**WEST SUSSEX COUNTY COUNCIL
STRATEGIC PLANNING CONSULTATION**

SUBJECT: EG/15/13 - Dropped kerb and driveway to front of property.

20, Gospond Road, Barnham, West Sussex, PO22 0EU

Existing Plan, Site & Block Plan.

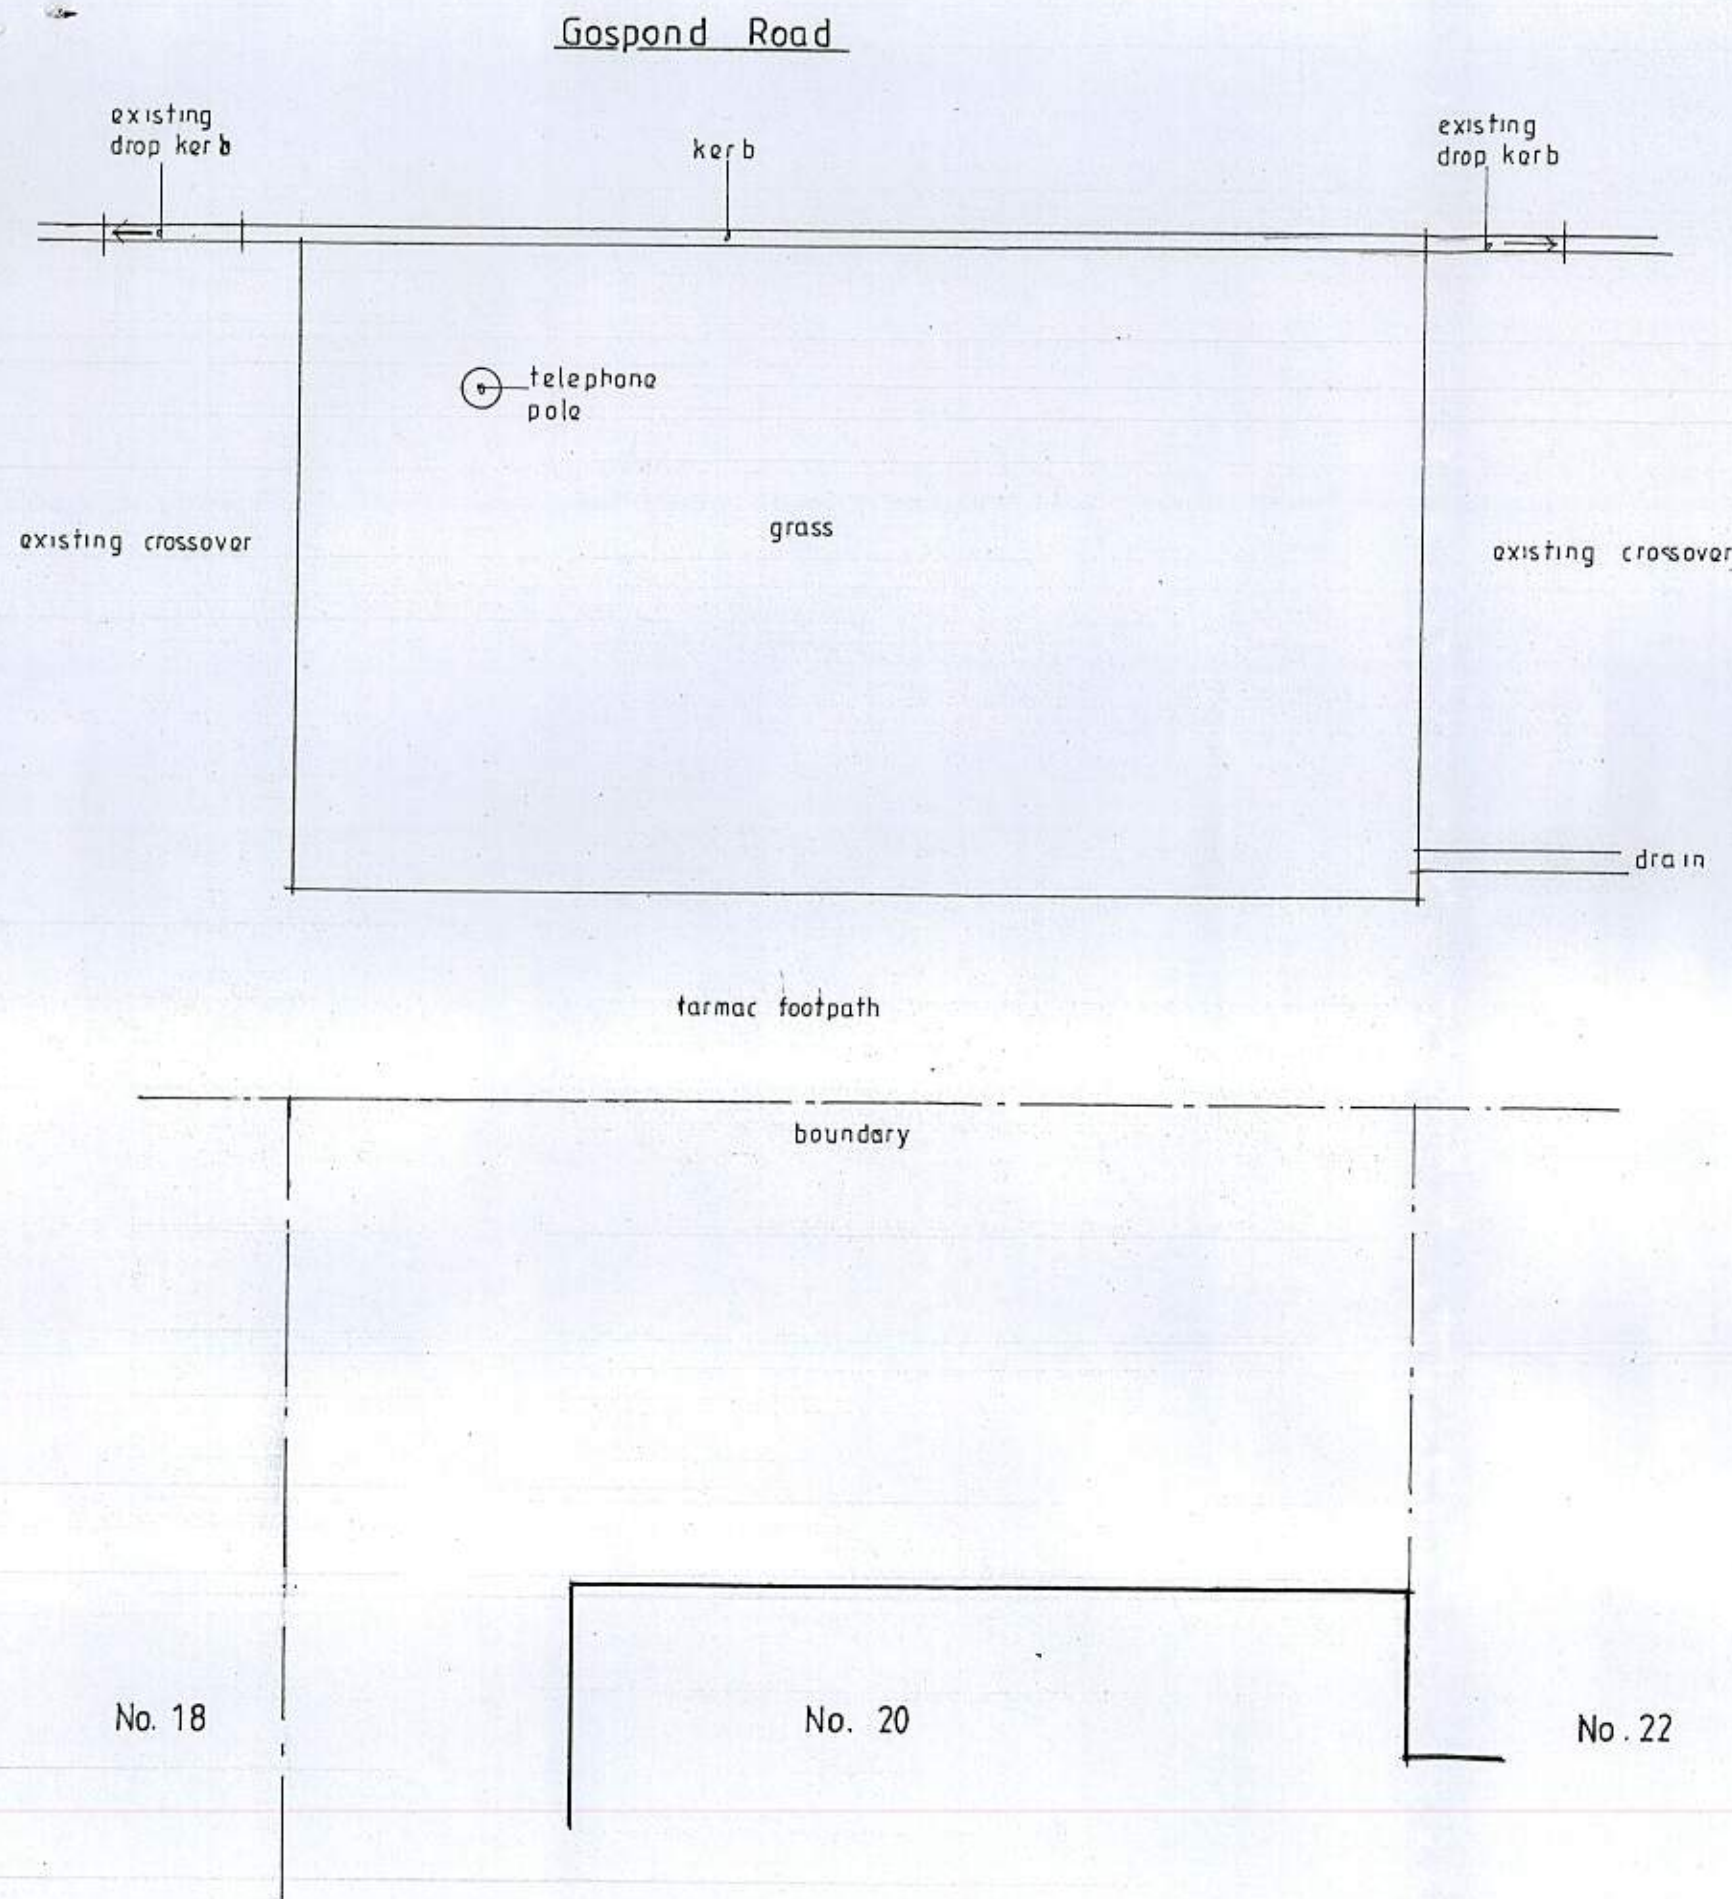
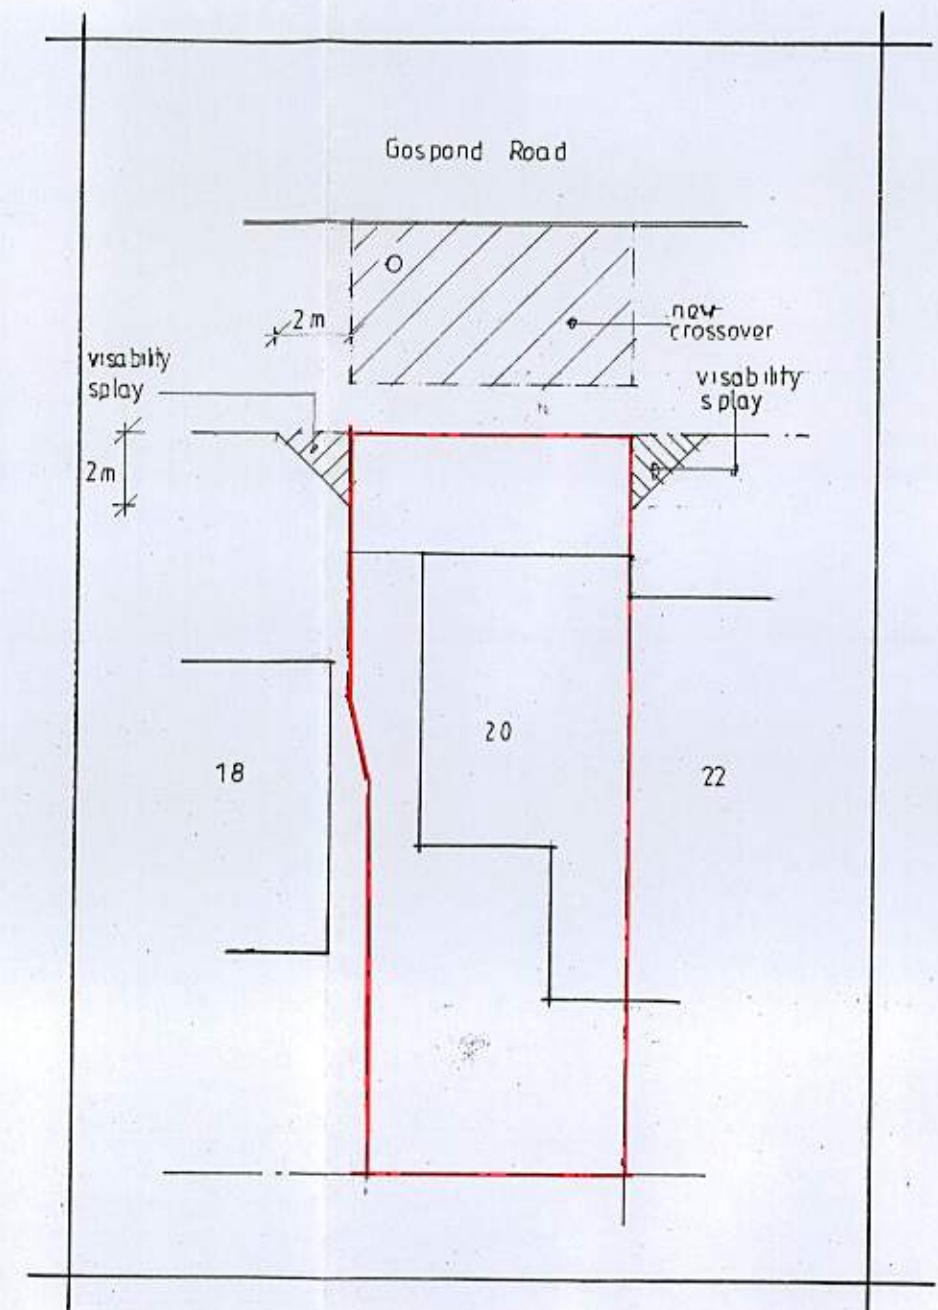
From inspection of the plans and information available it would appear the intention is for a vehicle to be parked on the property's frontage. This looks to be quite tight for a vehicle to be parked there without obstructing the footway that abuts the property boundary.

WSSC will require further information on a plan as to where it is intended vehicles to be parked on the driveway.
